Re: **Grain Dealers Brewery**
512 Creekside Dr
Raleigh, North Carolina

Architect Project No.23-117
Response to Building Plan Review

COMMERCIAL BUILDING REVIEW COMMENTS

PLATFORM FRAMING PLAN 3
1/2" = 1'-0"

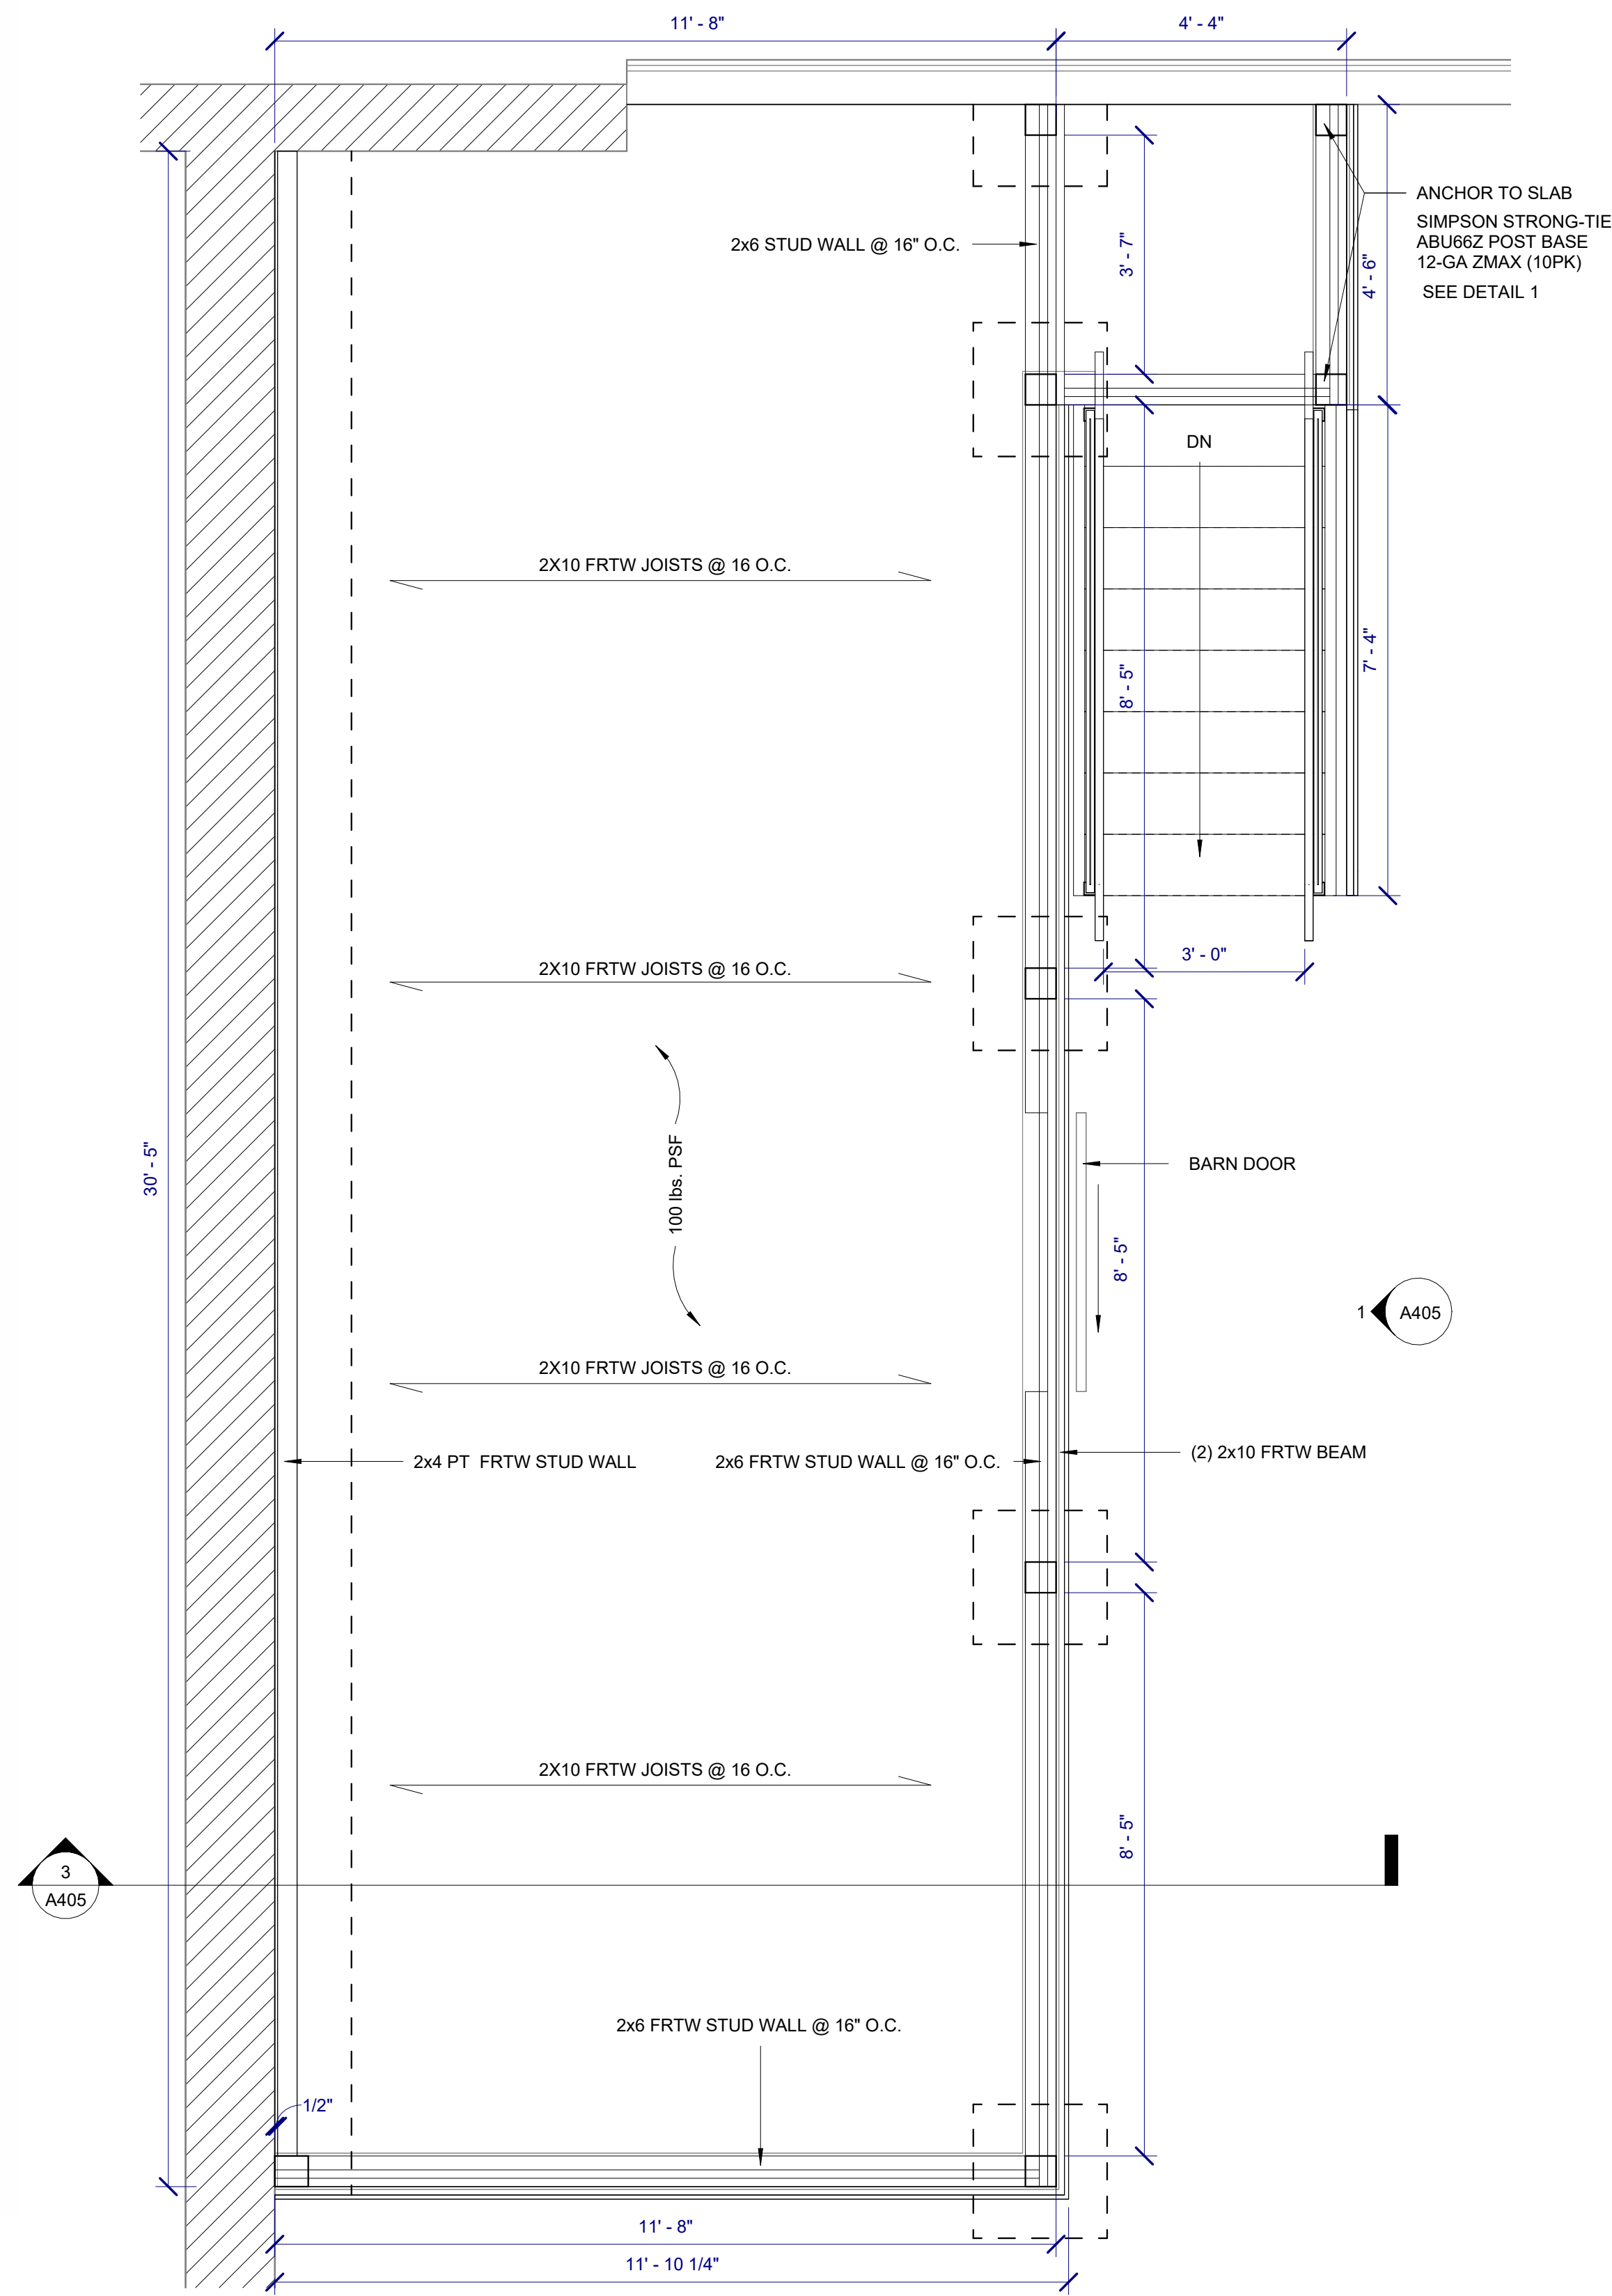
1. Raised platform above 30" with access. Provide 1 hr. floor design per 410.4

Response: The 1-hour fire-rated floor design was provided for the raised platform and is shown on Detail 2, Sheet A405.

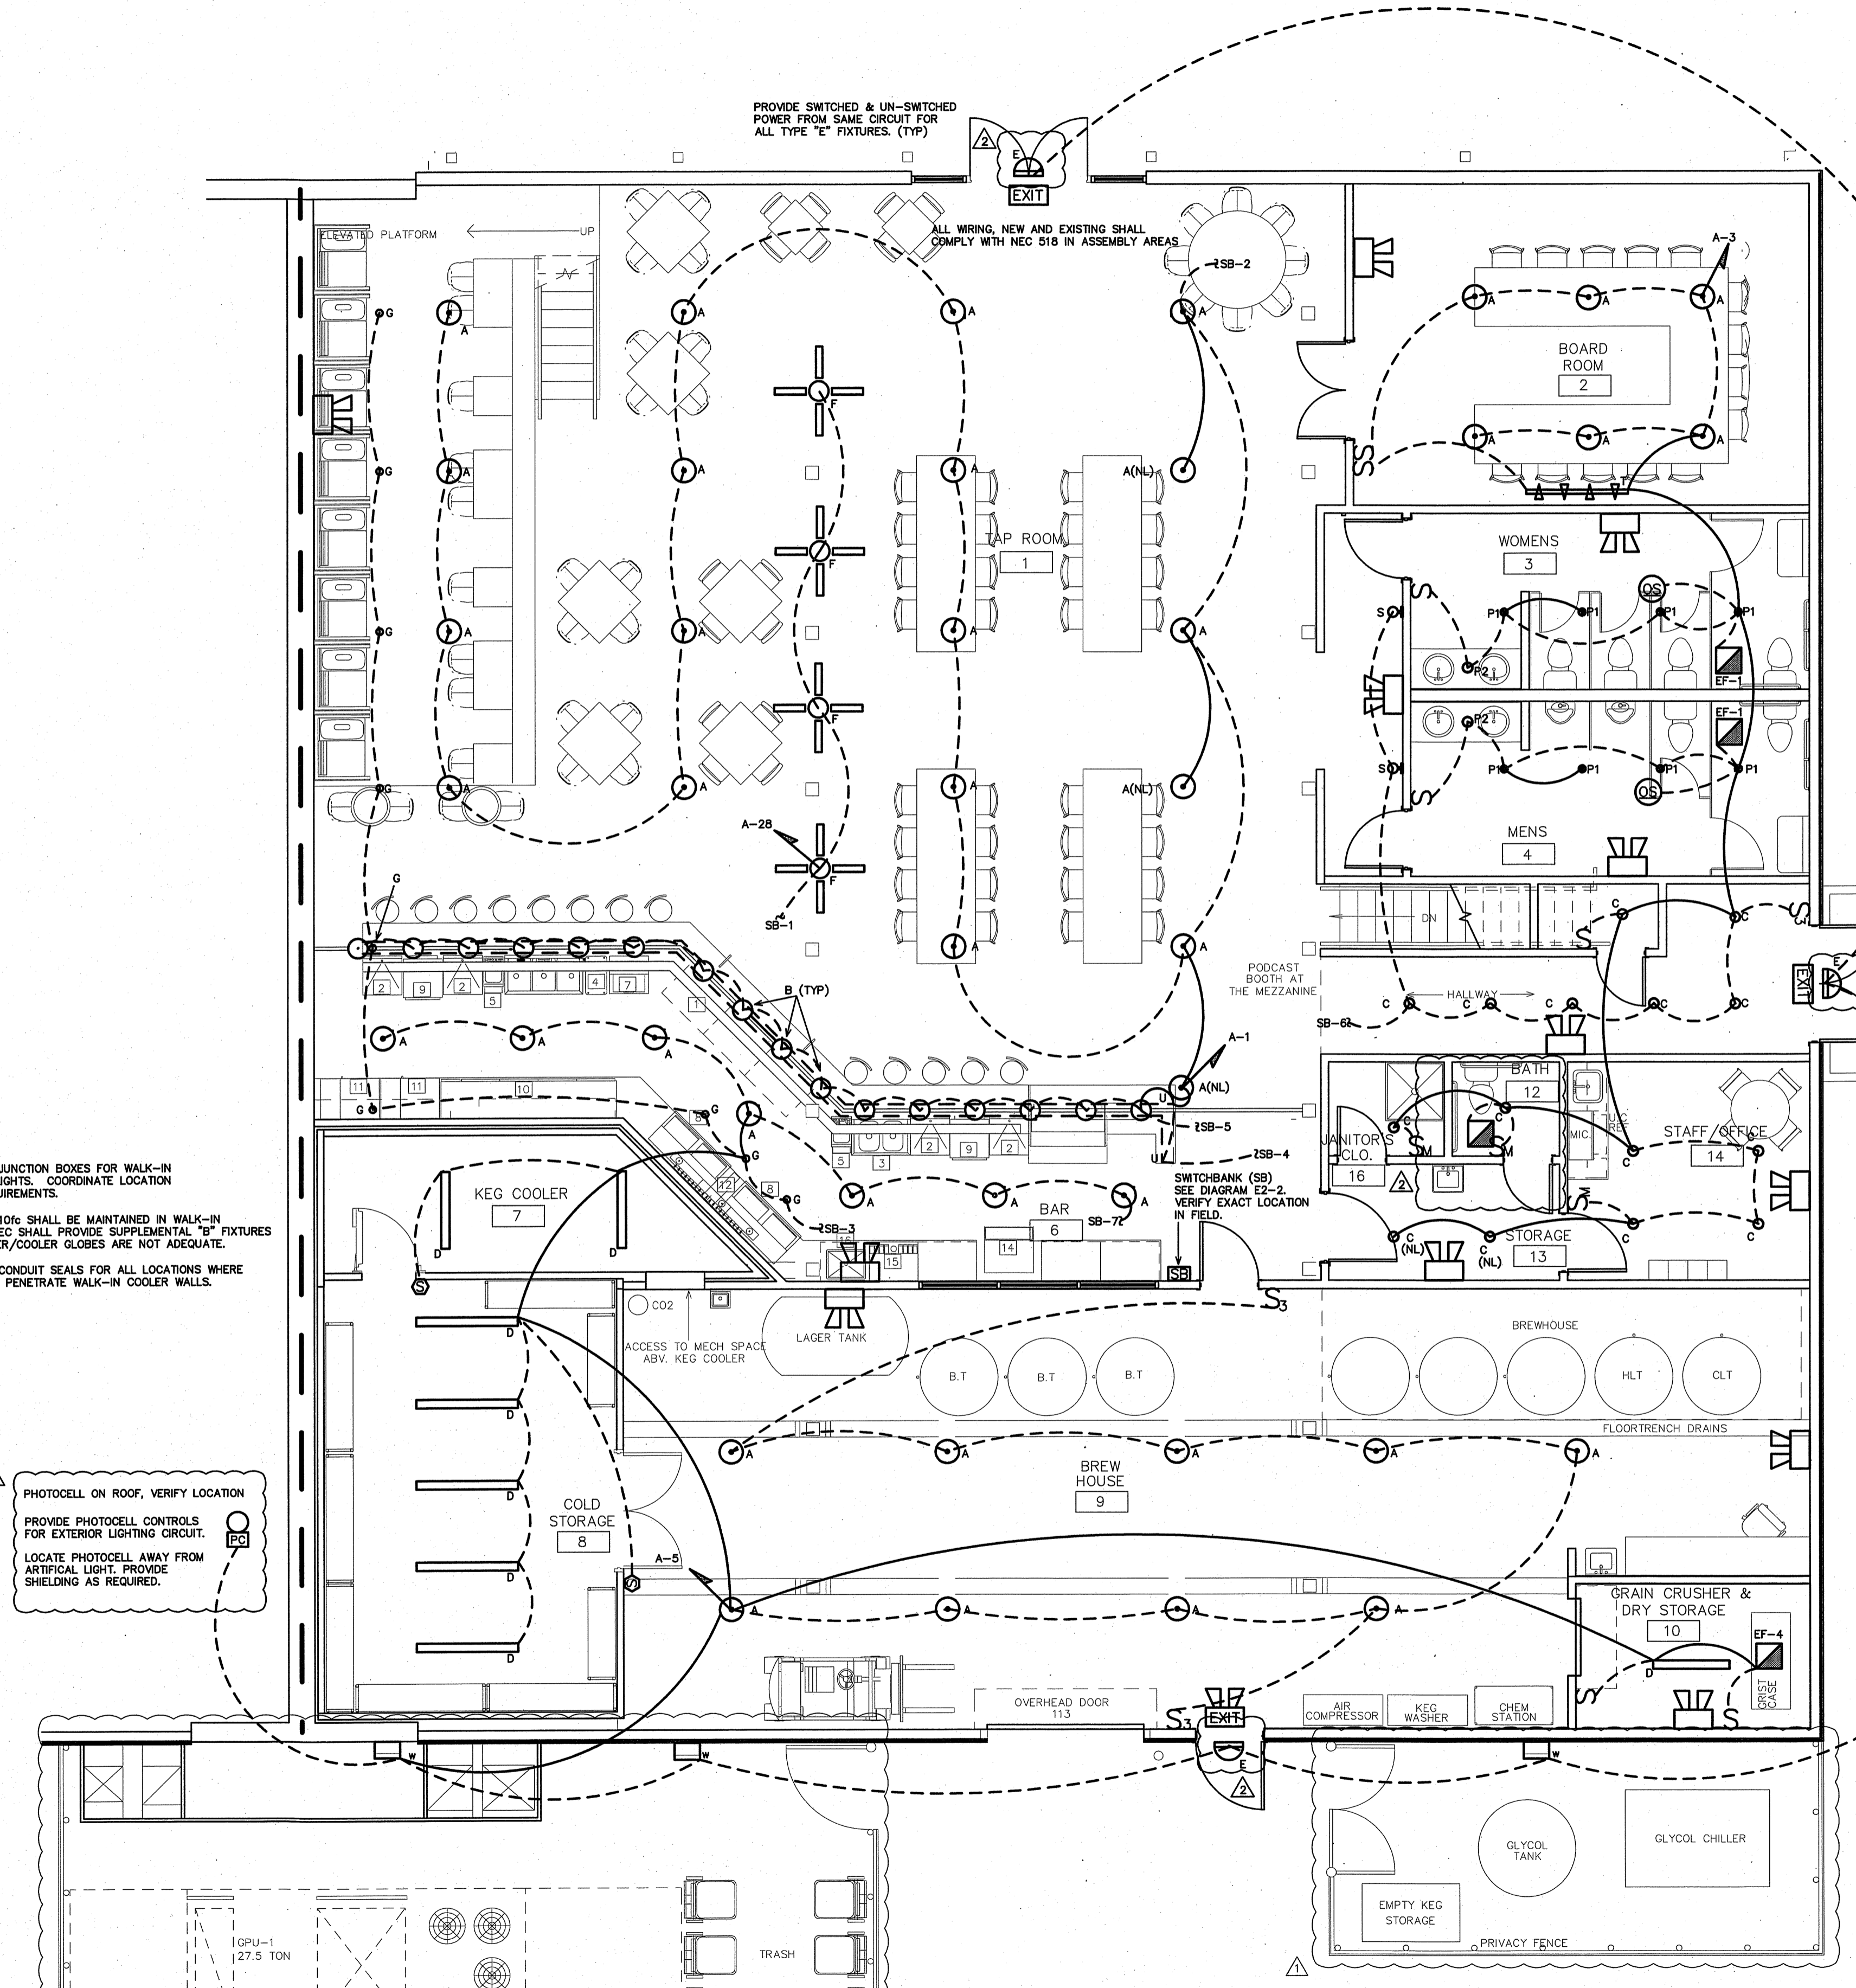
2. Lights in podcast booth shown as wall packs on ceiling? Also need emergency lighting in podcast area.

Response: SEE ATTACHED RESPONSE LETTER FROM BURKE DESIGN GROUP.
